PREFERRED PROJECT AND RESPONSE TO SUBMISSIONS REPORT

Modification of Project Application No. 06_0205 (Mod 2)

Vincentia District Centre

September 2010

Appendix D – Sketch of Options

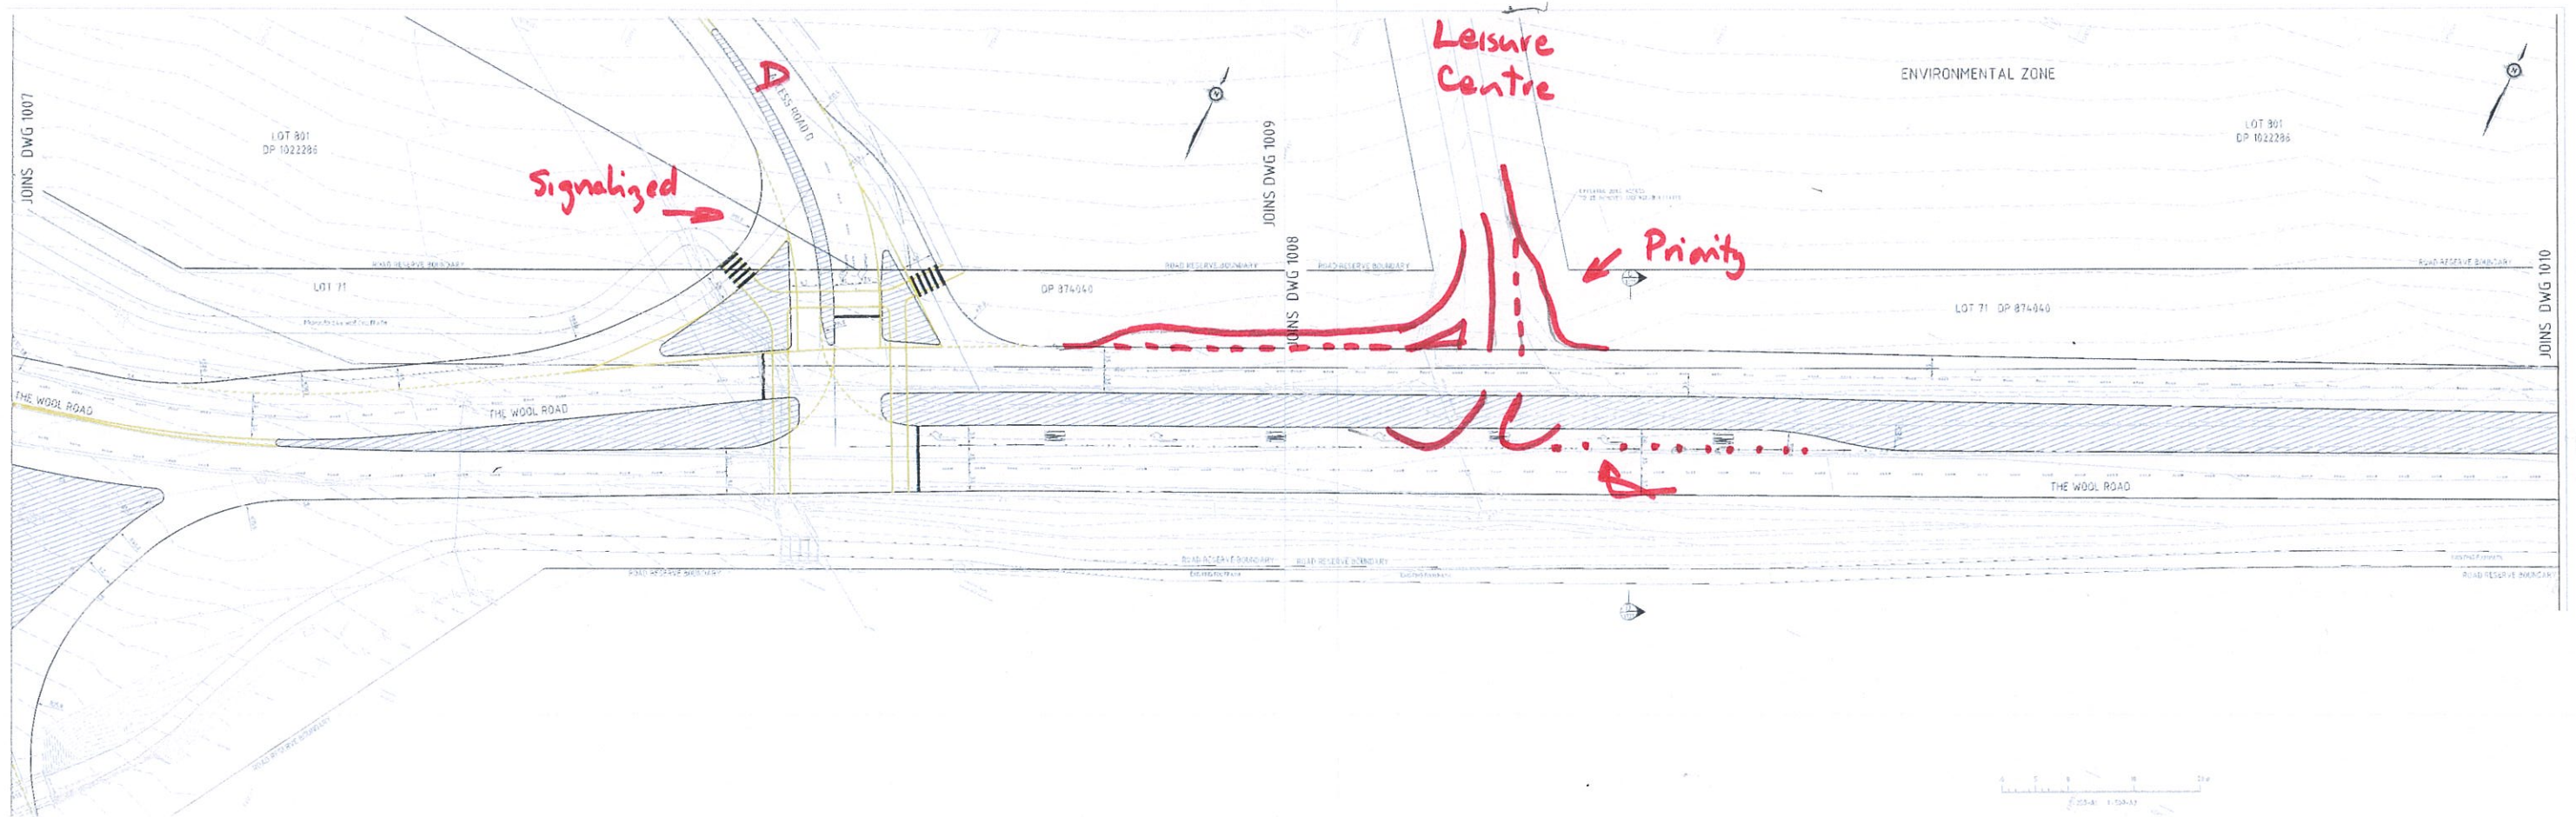
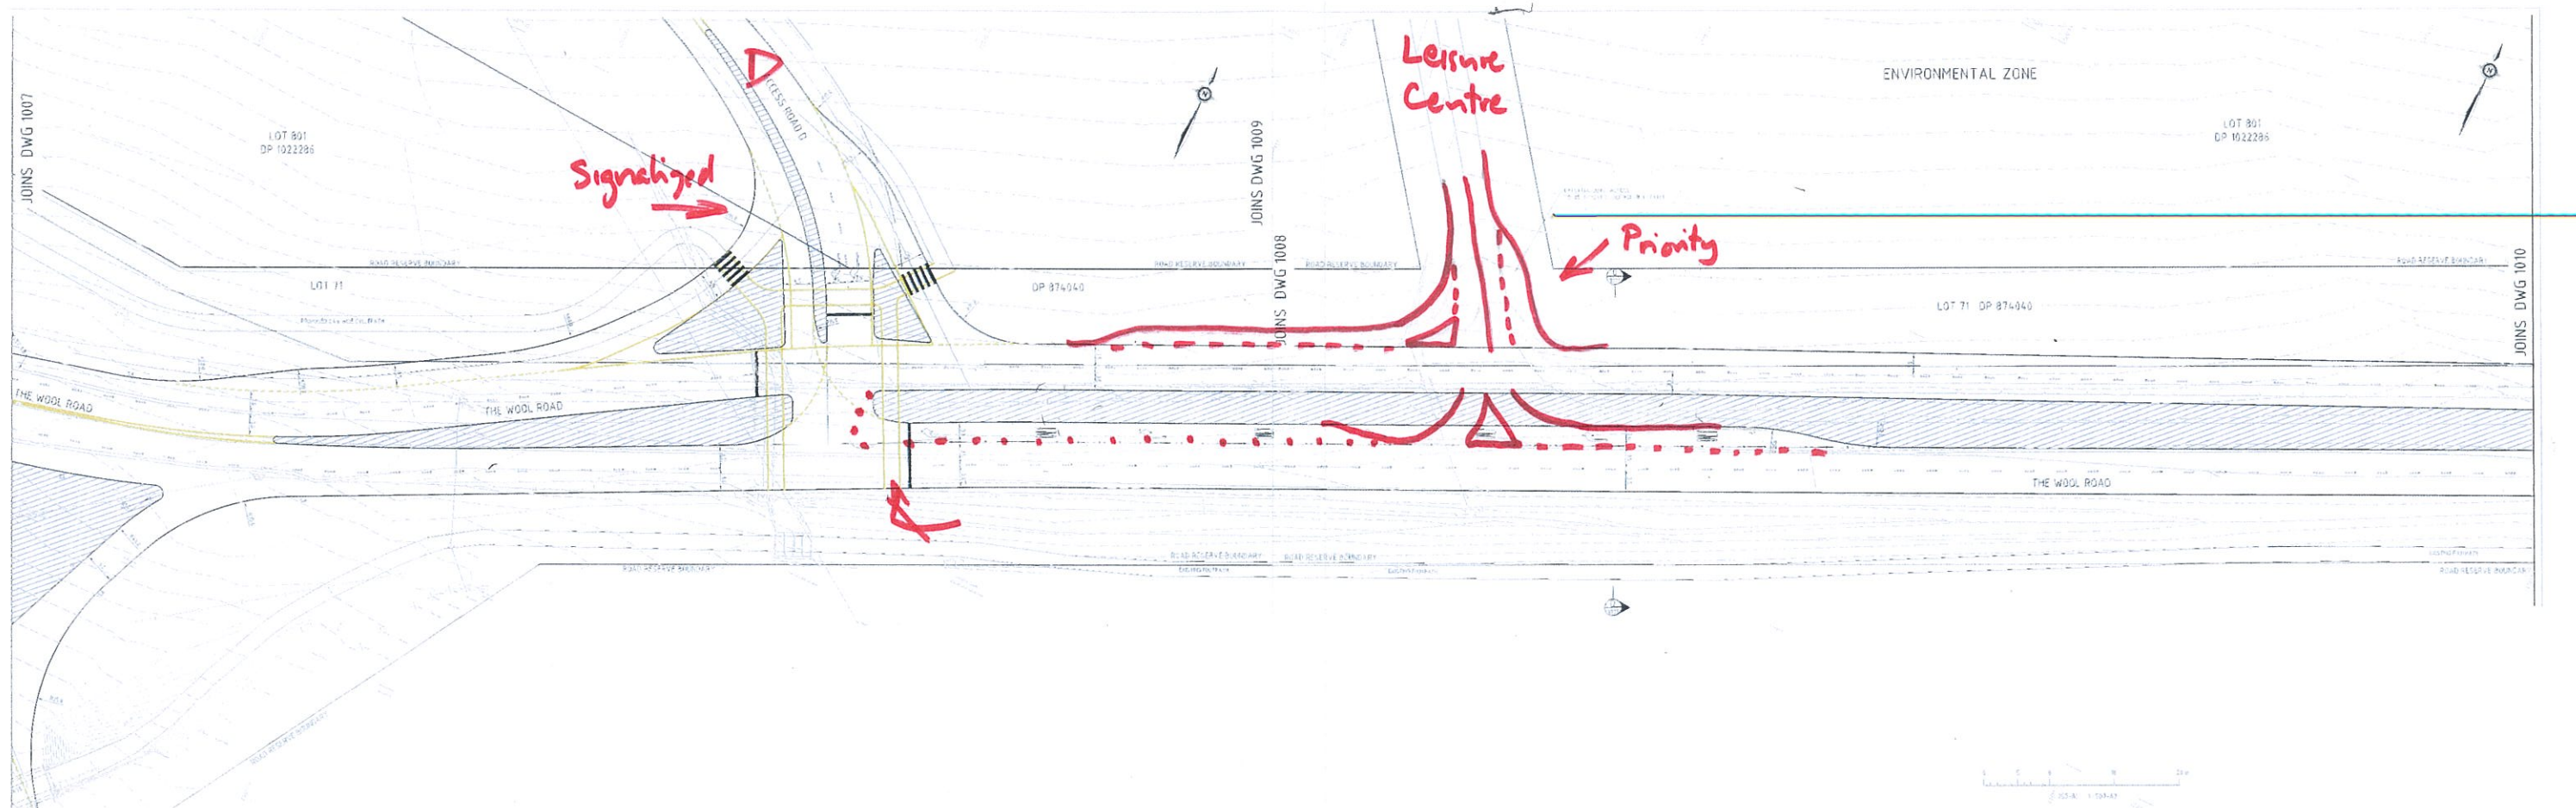
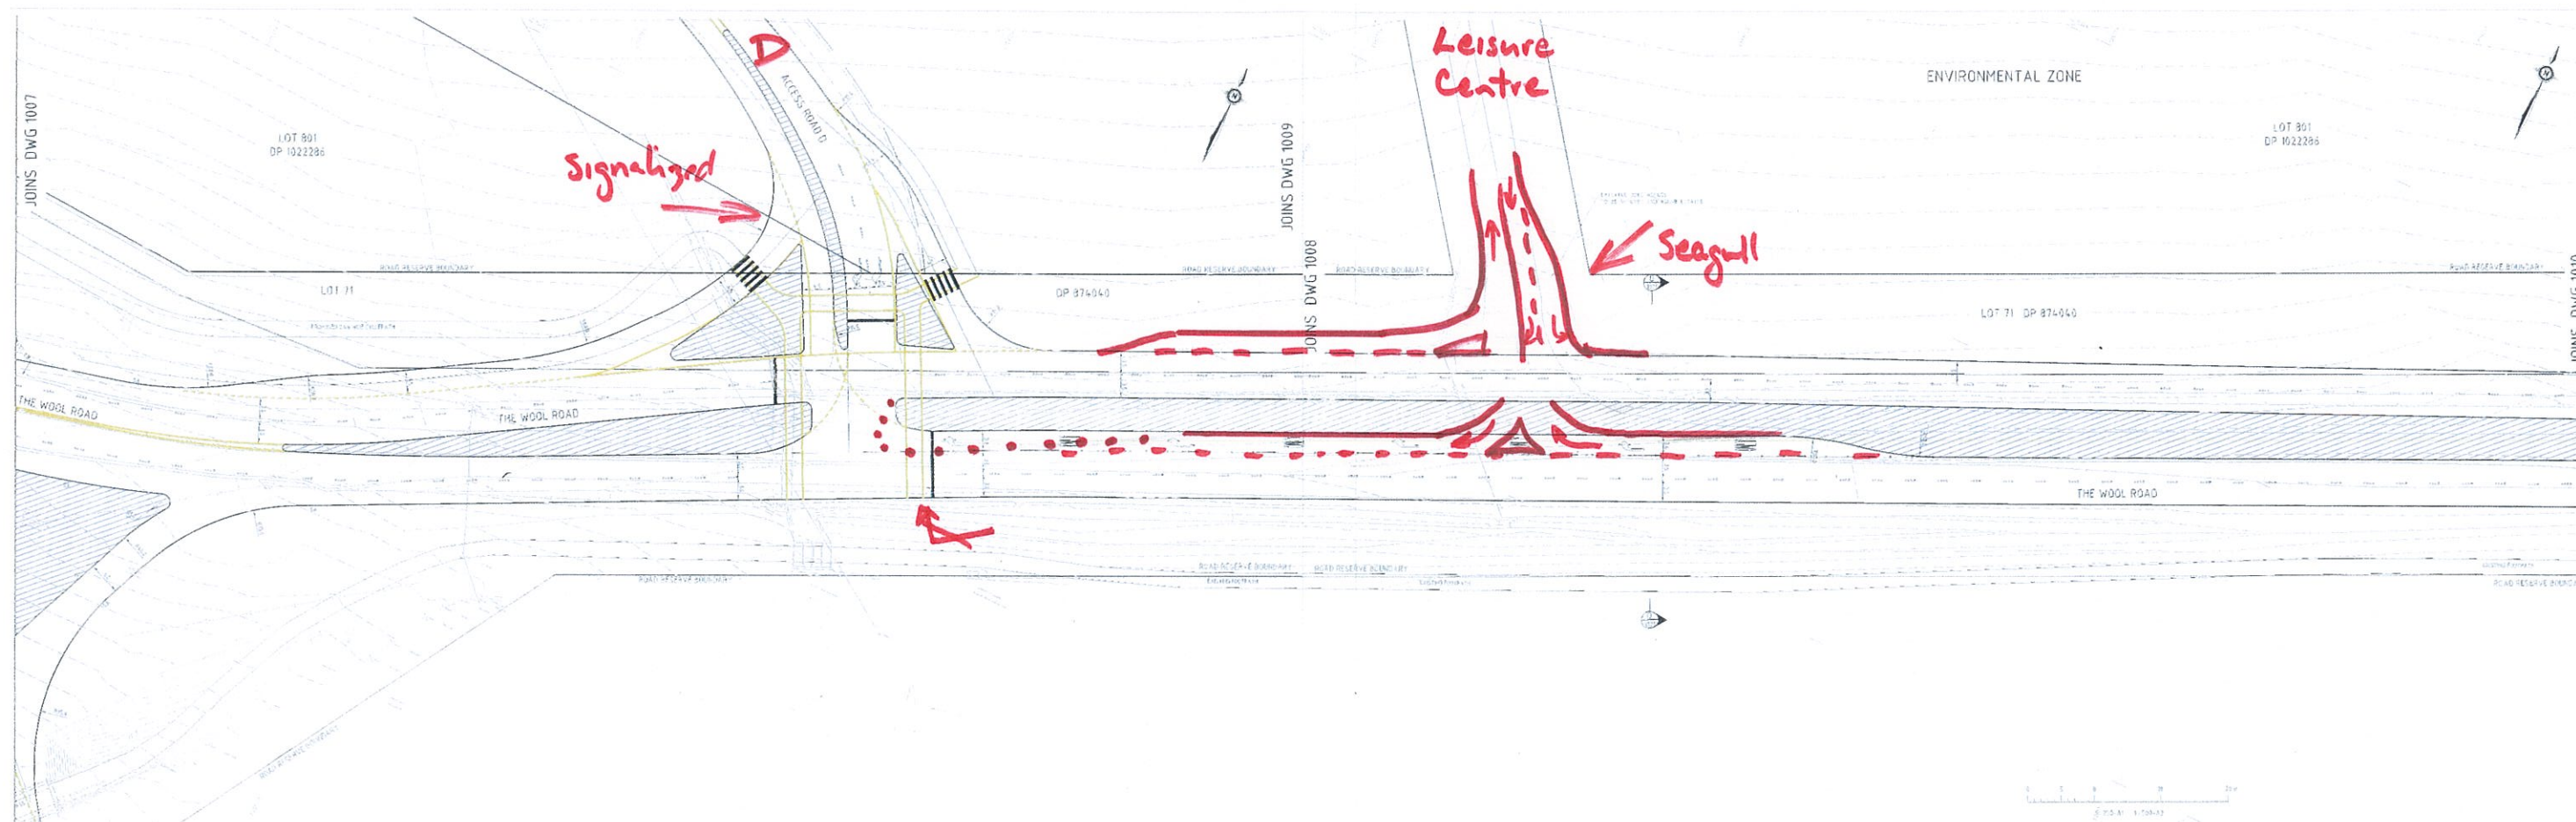
*It is considered that the issues presented for the new Intersection E and the access road to the BBLC precinct must be resolved and the work done and completed before the occupation of VDC Stage 1. Should the Department enable the new access D while the future of the existing BBLC access road remains and issues for the new access remain unresolved a critical traffic safety issue for those using this part of The Wool Road will result. **Council considers the traffic safety issues for this part of The Wool Road cannot be underestimated or ignored.***

In this regard, Halcrow have considered three options in their report titled “Vincentia District Centre Proposed Temporary Access” dated 30 September 2010, which can be found at **Appendix C**, including:

It should be noted that for the Leisure Centre access, the layout sketches show an additional intersection leg opposite the Leisure Centre access labled RTSB merge. This stands for Right Turn South Bound merge and is a dummy approach added into the SIDRA model to take into account extra delay to vehicles turning right out of the Leisure Centre access when they merge with southbound traffic in The Wool Road.

Based on the above analysis and considerations we recommend Option 3 as the most appropriate option for temporary access to the Leisure Centre.

The temporary access arrangements for The Wool Road are referred to in the drawings prepared by Cardno as Stage 1A, with the full upgrade works for The Wool Road inclusive of the new access to the BBLC known as Stage 1B.

<p>Action</p>	<p>Commitment 28:</p> <p>Fabcot will design and construct the works proposed in The Wool Road in two stages. Stage 1A will involve temporary works to the existing intersection of the Bay and Basin Leisure Centre access road at The Wool Road as shown in Appendix C by Cardno.</p> <p>Fabcot will design and construct the signalised intersection of The Wool Road, the access road to the Bay and Basin Leisure Centre and the access to the Vincentia High School as Stage 1B in accordance with the intersection configuration as shown in Appendix C by Cardno.</p> <p>All preliminary environmental investigations, reports, approvals and all other approvals required by the authorities prior to allowing construction of the Bay and Basin Leisure Centre access over Council's land will be at nil cost to Fabcot.</p> <p>Timing:</p> <p>Fabcot will commence construction of Stage 1B works in The Wool Road and adjacent land within 12 months of the issue of a Construction Certificate for the new access road to the Bay and Basin Leisure Centre.</p>
